External alteration of new 'catslide' tiled roof over garage, new balustrade to existing balcony
& external material alterations

25 Kingsway Aldwick PO21 4DH

External alteration of new 'catslide' tiled roof over garage, new balustrade to existing balcony & external material alterations
25 Kingsway Aldwick

I regret that I am unable to accept your documents as a formal application until the following matters have been resolved :-

sheet 2 of 2

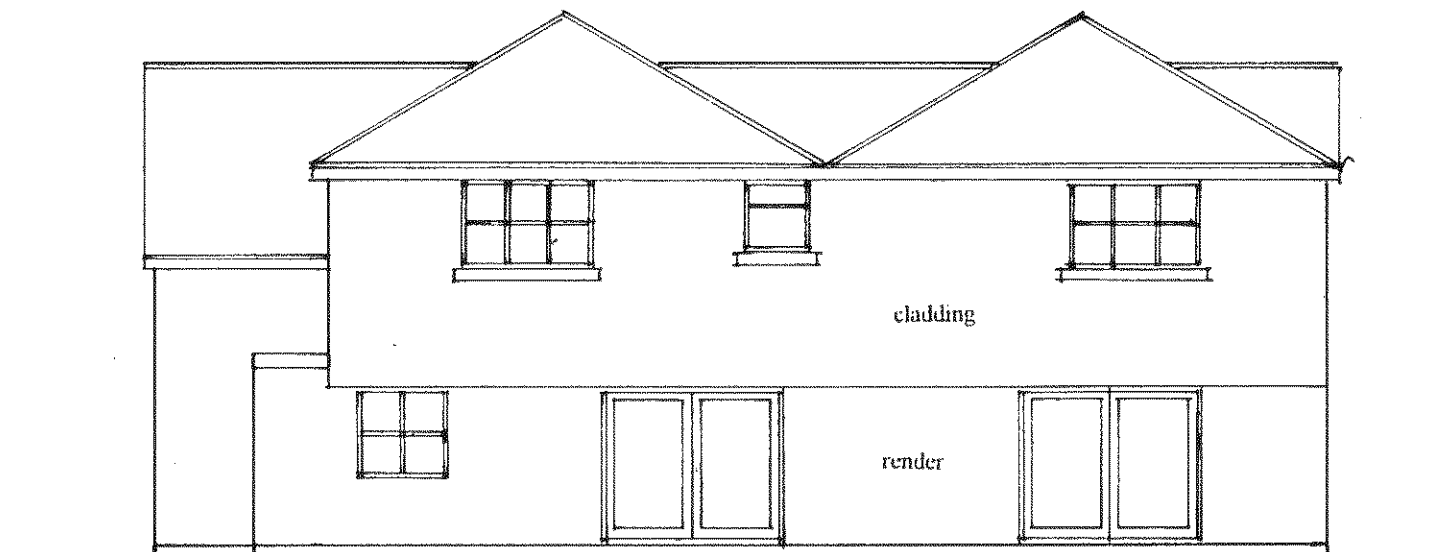
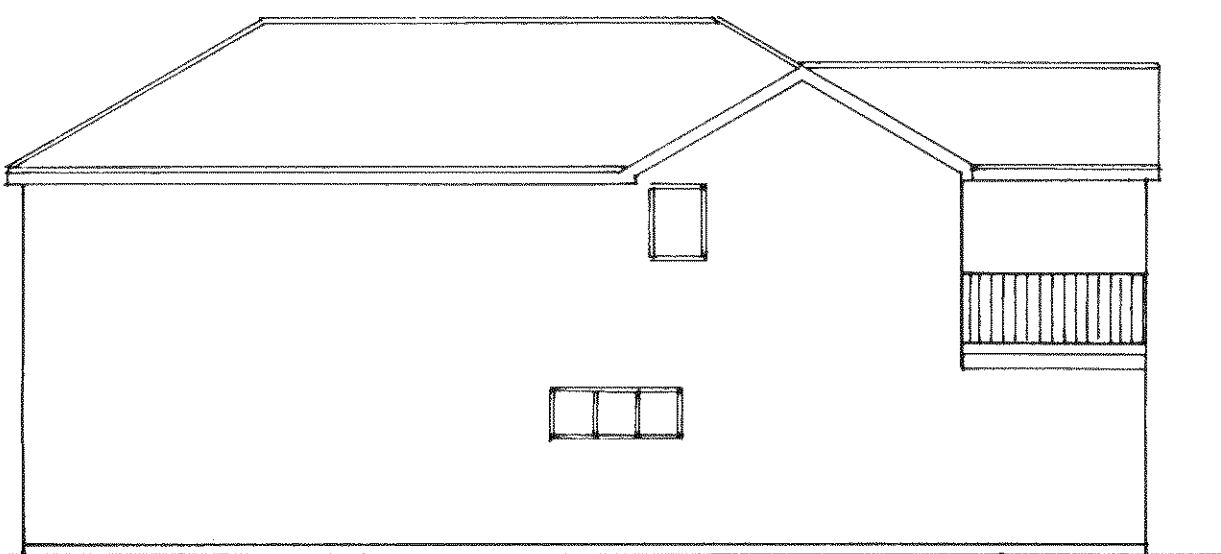
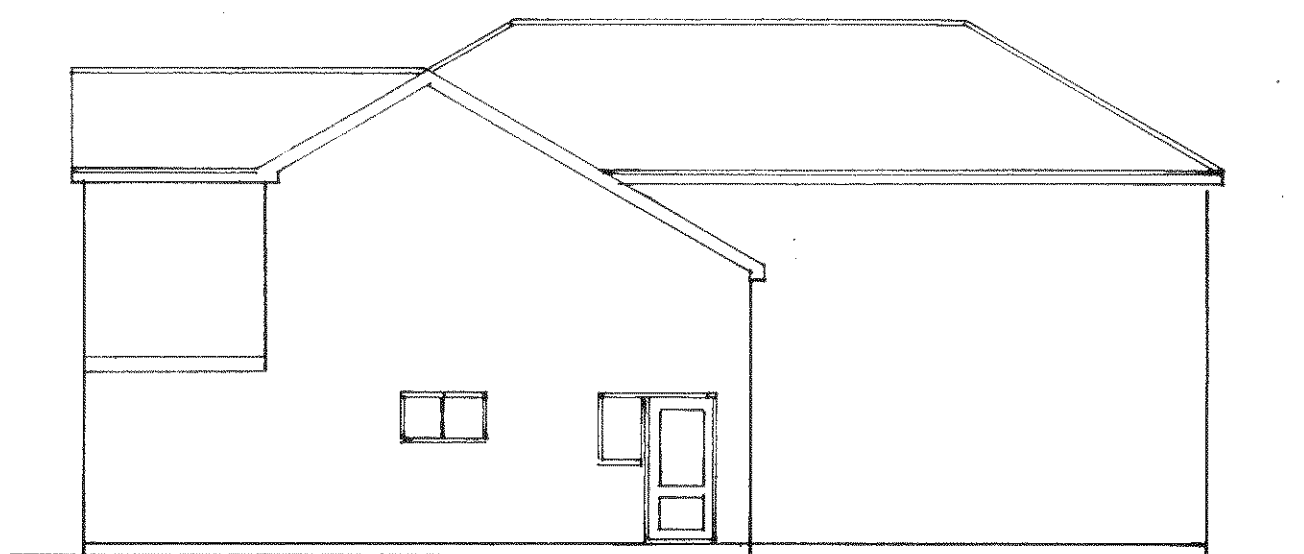
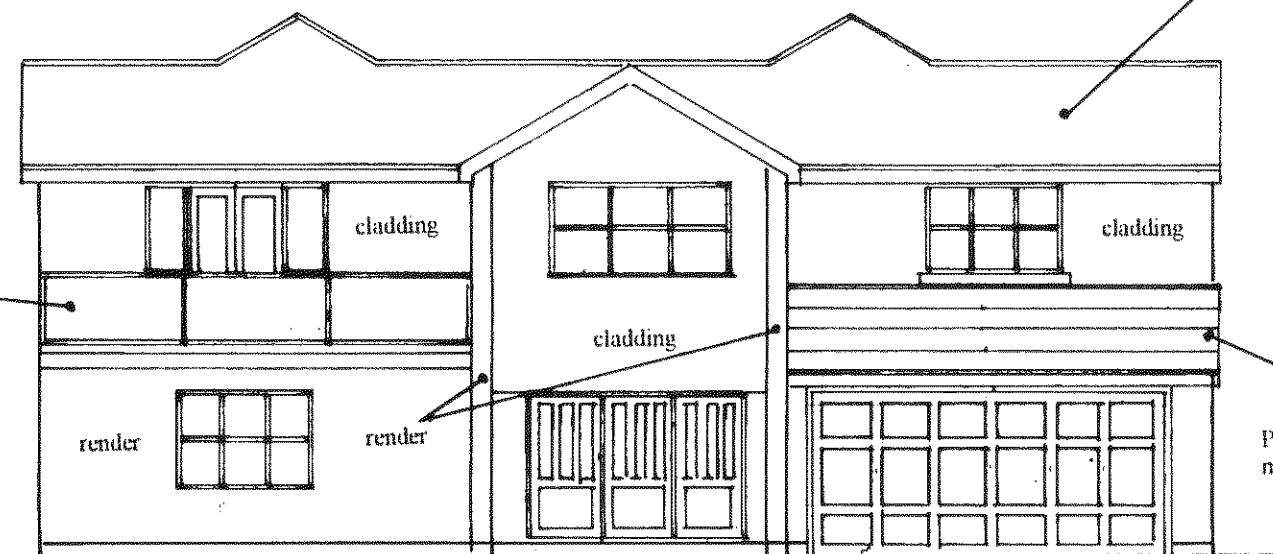
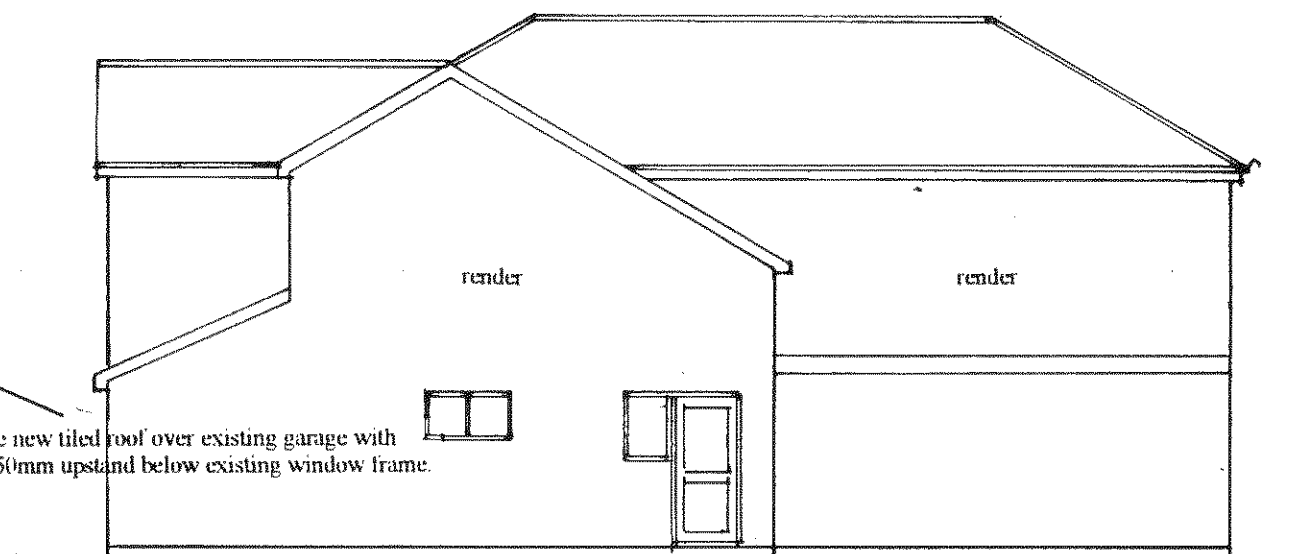
Please confirm which North elevation is existing and proposed.
